**RE: HOMESTEAD FILING 2 – PRELIMINARY ACCEPTANCE PUNCHLIST FOR FULL SPECTRUM DETENTION POND 1**

**RE: HOMESTEAD FILING 2 – VOLUME CERTIFICATION LETTER FOR FULL SPECTRUM DETENTION POND 1**

FDS POND 1 EMERGENCY SPILLWAY AND RUNDOWN TO SAND CREEK CHANNEL
1"=10'

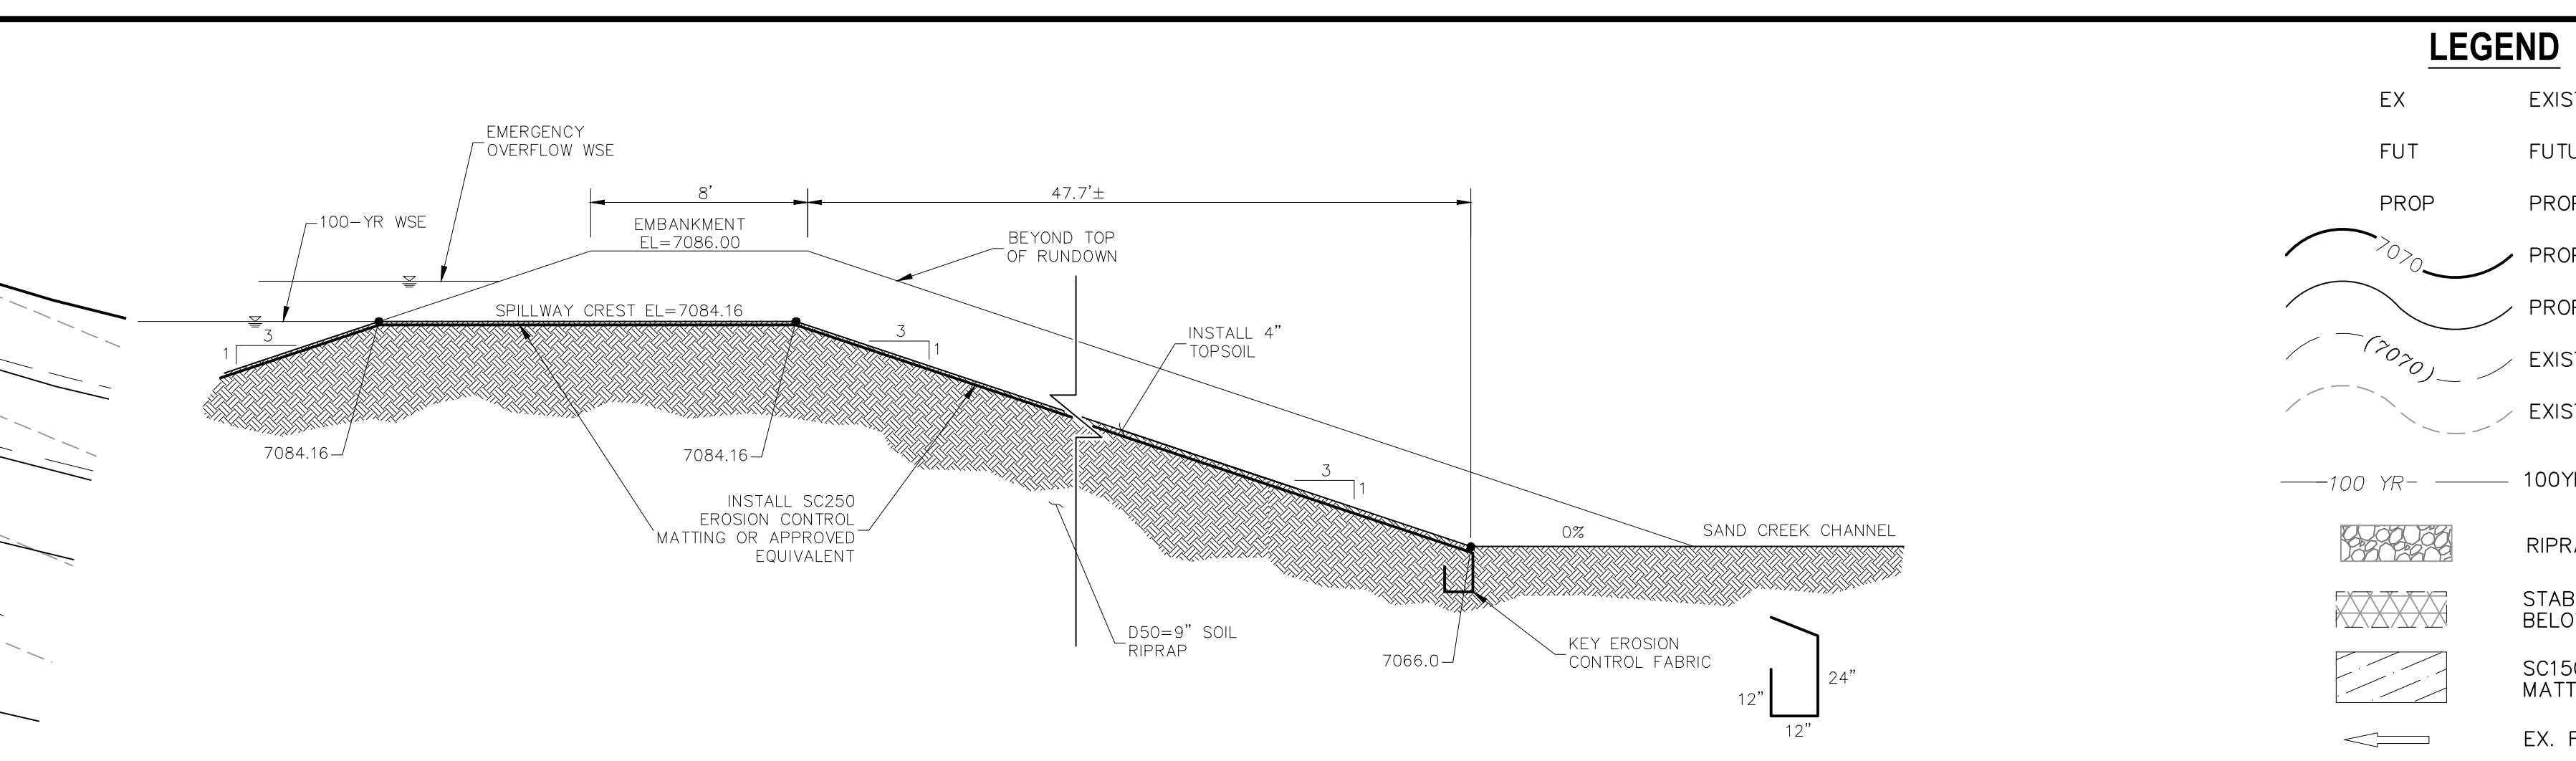
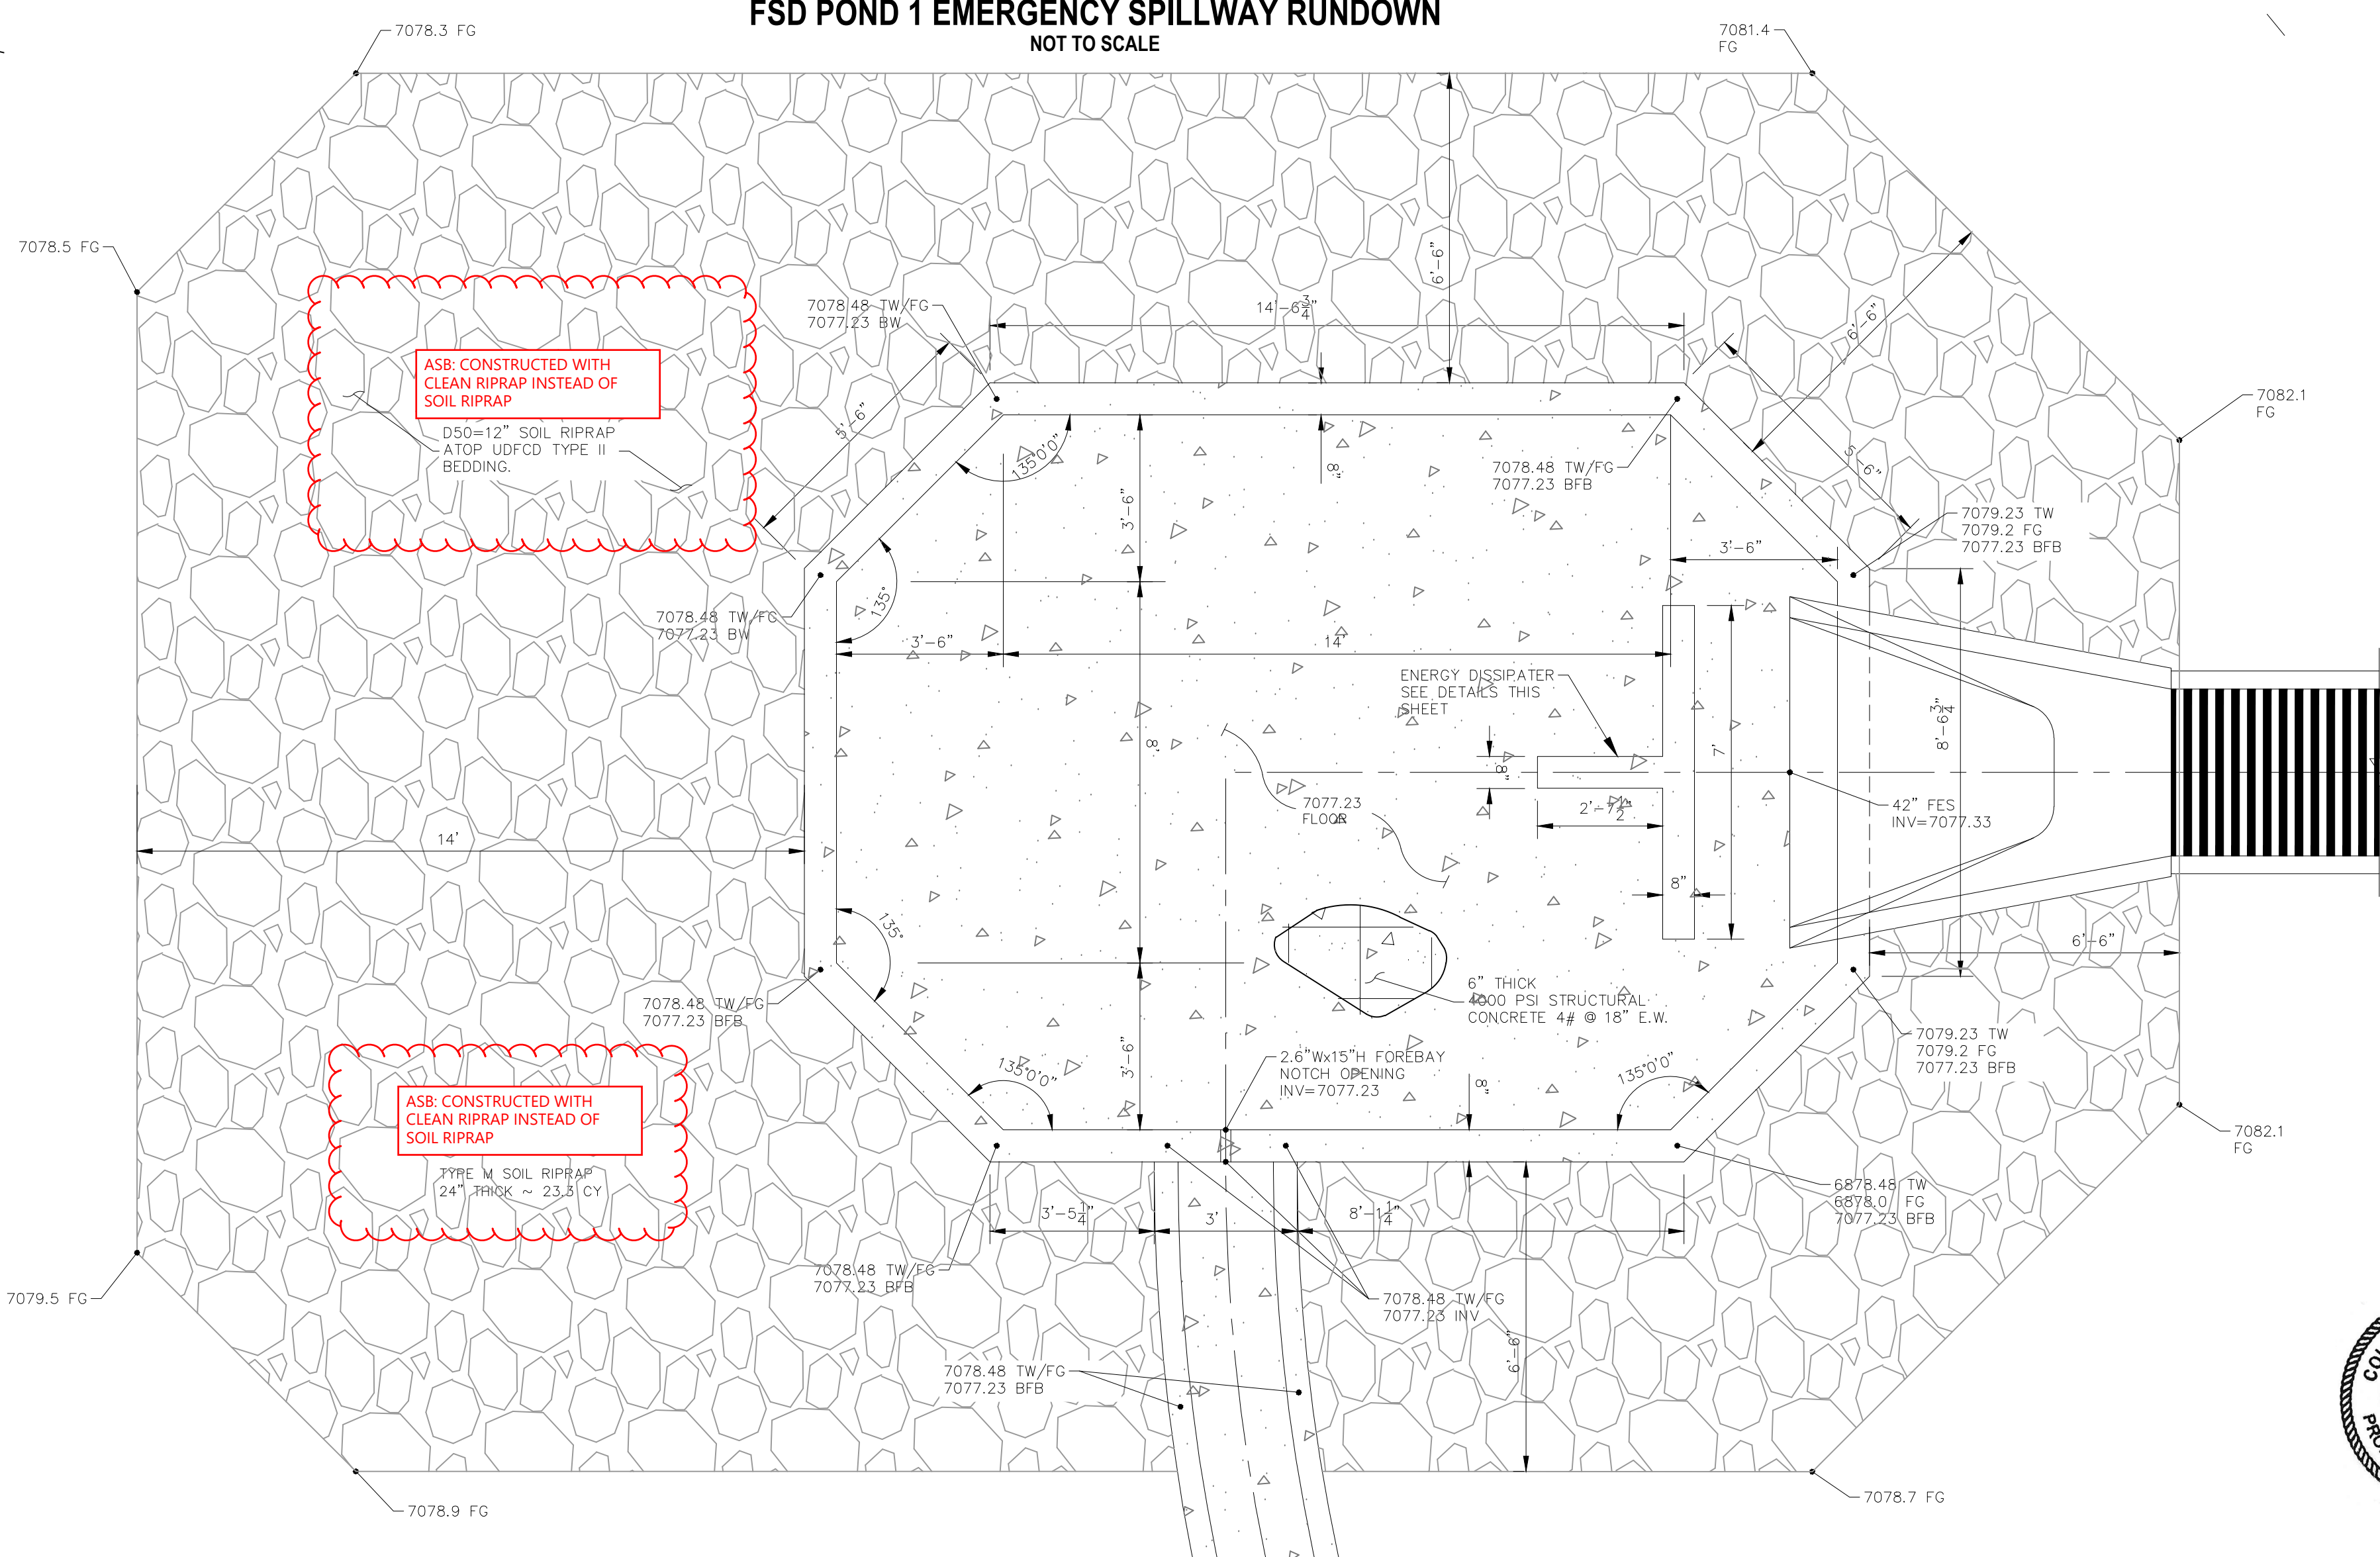
1. Micro screen installed with V-wire bars are horizontal and not vertical
2. Pond outfall not installed per plans. Plunge pool approved, 8' x 30' riprap pad installed. Discuss need for concrete cut-off wall
3. Shown plain riprap around forebay, instead of soil riprap
4. Restrictor Plate Height
5. Flat portion of Section A-A (spillway) is installed at less than 20 ft wide.

#### Spillway Width

The spillway was proposed at 20' in the approved construction documents. However, it was constructed 16' wide. The UD-Detention 3.07 spreadsheet for Pond 1 has been updated with the 16' spillway width and confirms the spillway will pass the undetained 100-year flow with 1.0' freeboard. Therefore, I recommend the 16' spillway remain as is.

FOREBAY PLAN
SCALE: 3/8" = 1'

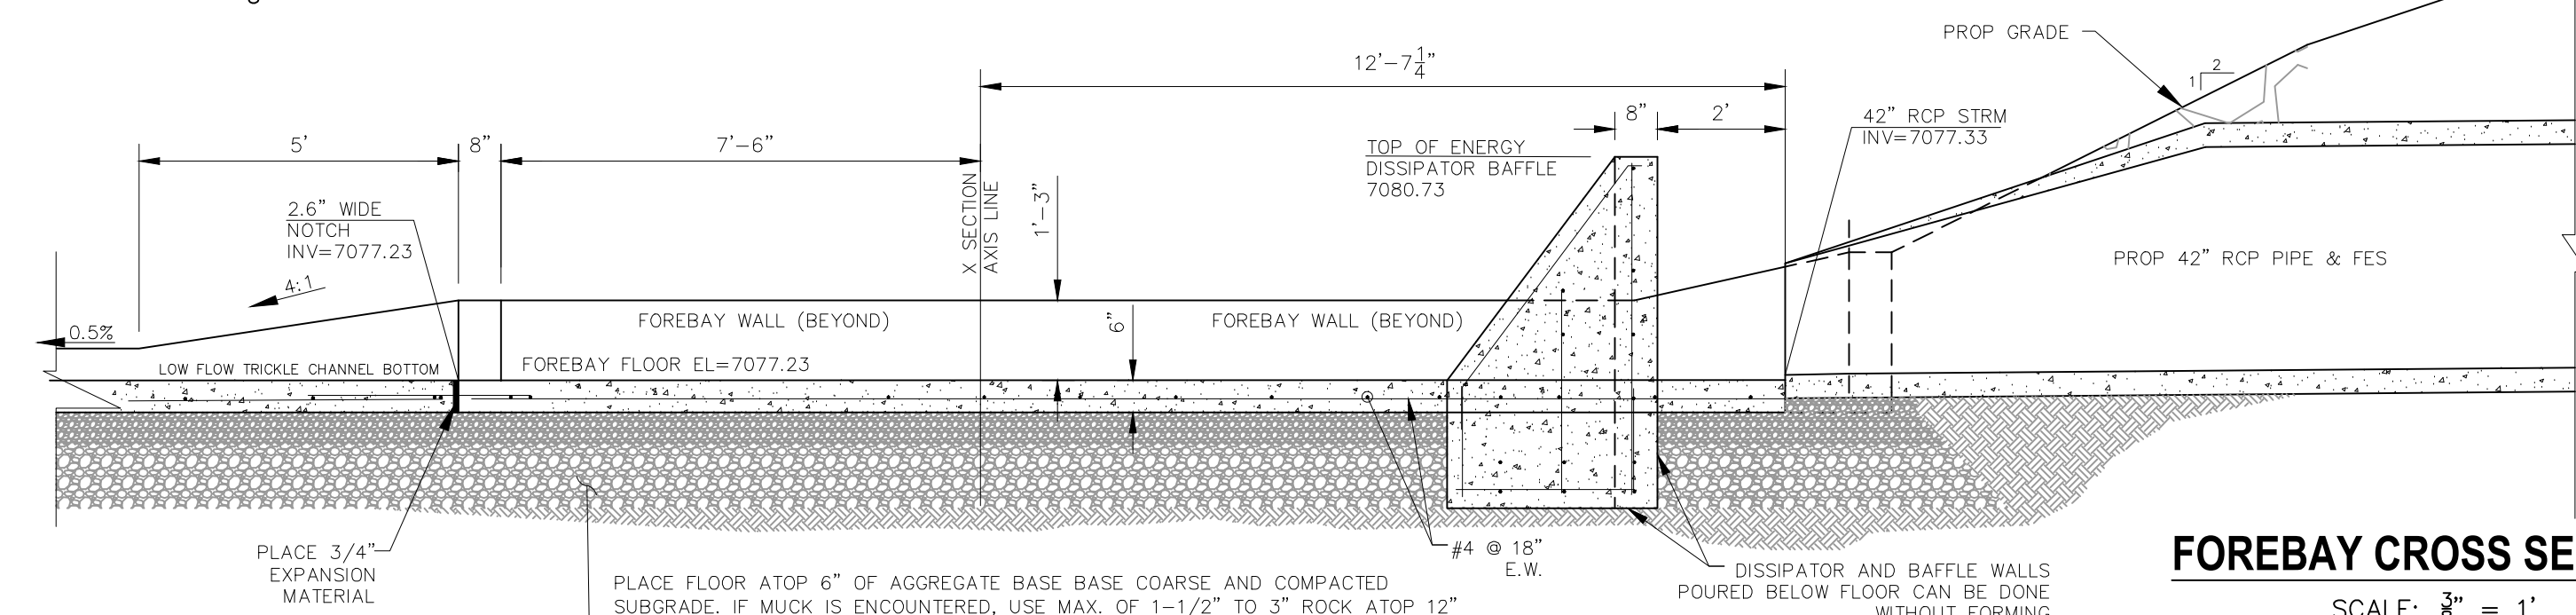
Forebay Riprap

The reason for calling out soil riprap for the forebay protection is that soil riprap gives a finished look and can be revegetated, however; both clean riprap and soil riprap are acceptable erosion protection treatments around the forebay. Therefore, I recommend the clean riprap remain around the forebay.

24" OUTFALL INTO SAND CREEK
1"=5'

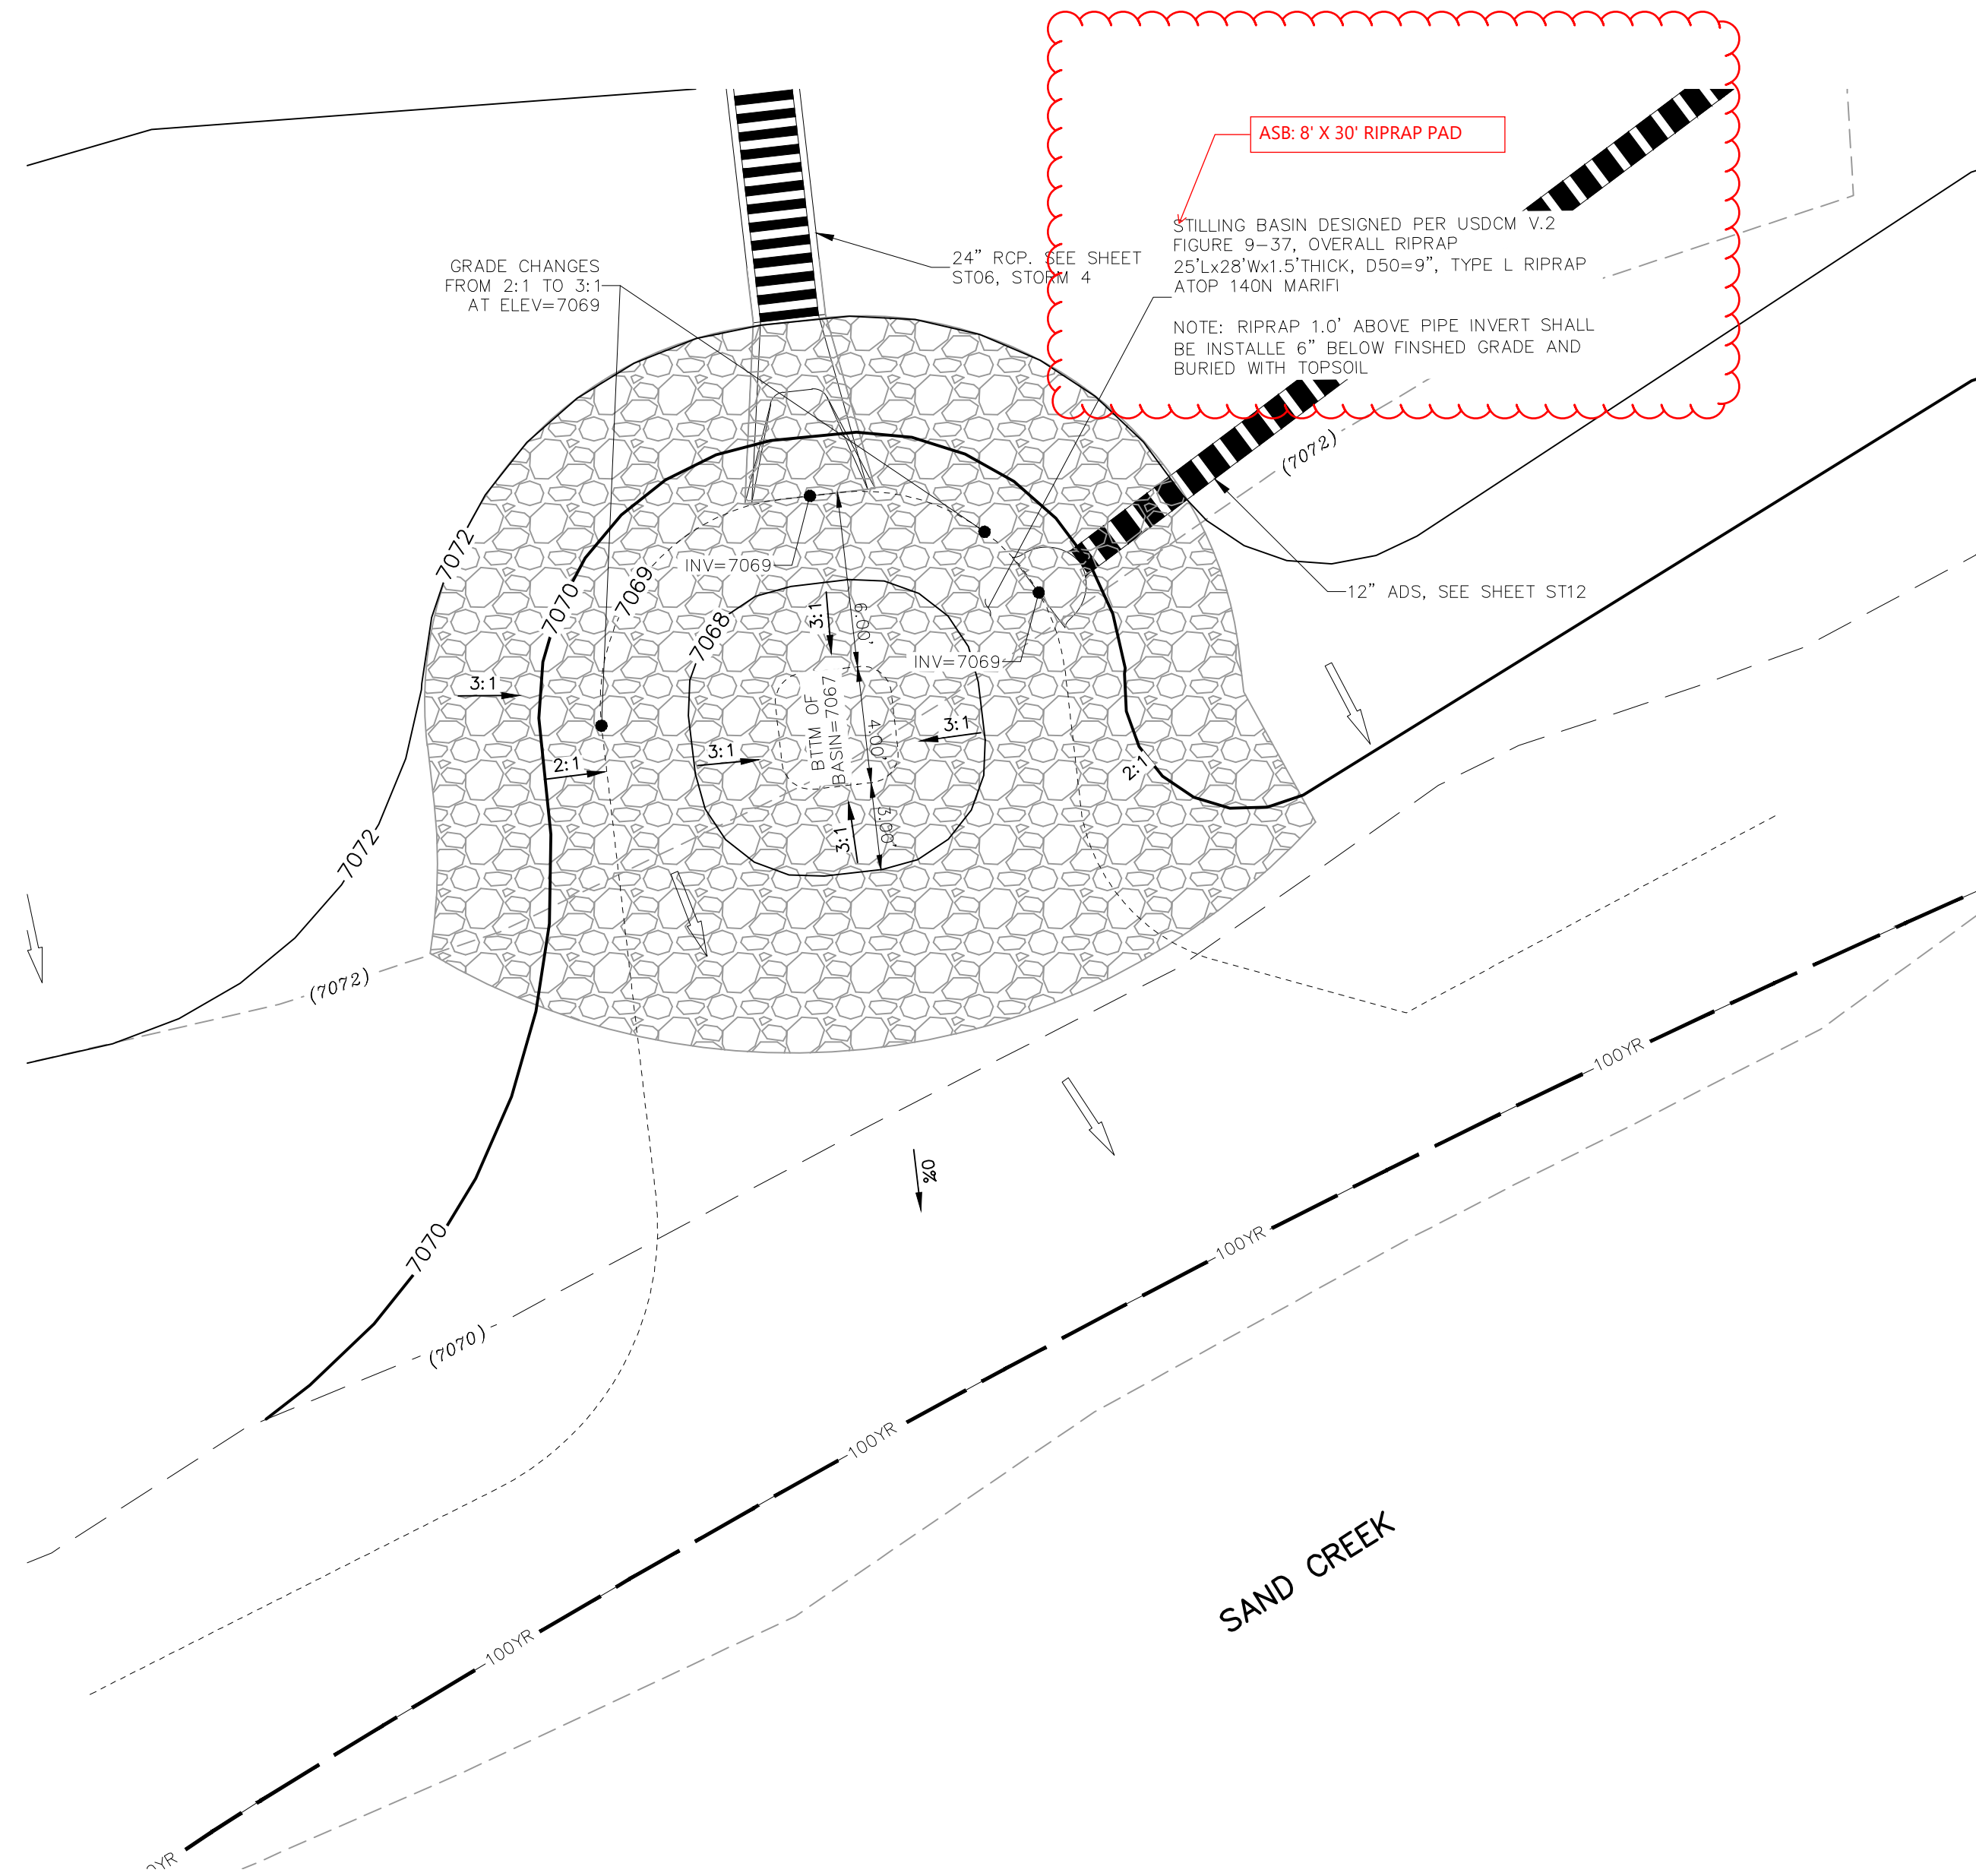
Pond Outfall

The pond outfall was constructed with an 8' x 30' Type L riprap pad. The riprap pad provides the necessary energy dissipation for the pond outfall. See attached riprap sizing for verification. This as-built condition is temporary, as the outfall will be modified to discharge onto a grouted boulder drop-structure with the Sand Creek Channel Improvements. Therefore, I recommend that the riprap pad as constructed be accepted as the Pond 1 outfall erosion protection. A concrete cut-off wall is not necessary in our opinion. Any undermining should be filled with Type L Riprap, should it occur. We believe the observed undermining was a result of incomplete riprap placement.
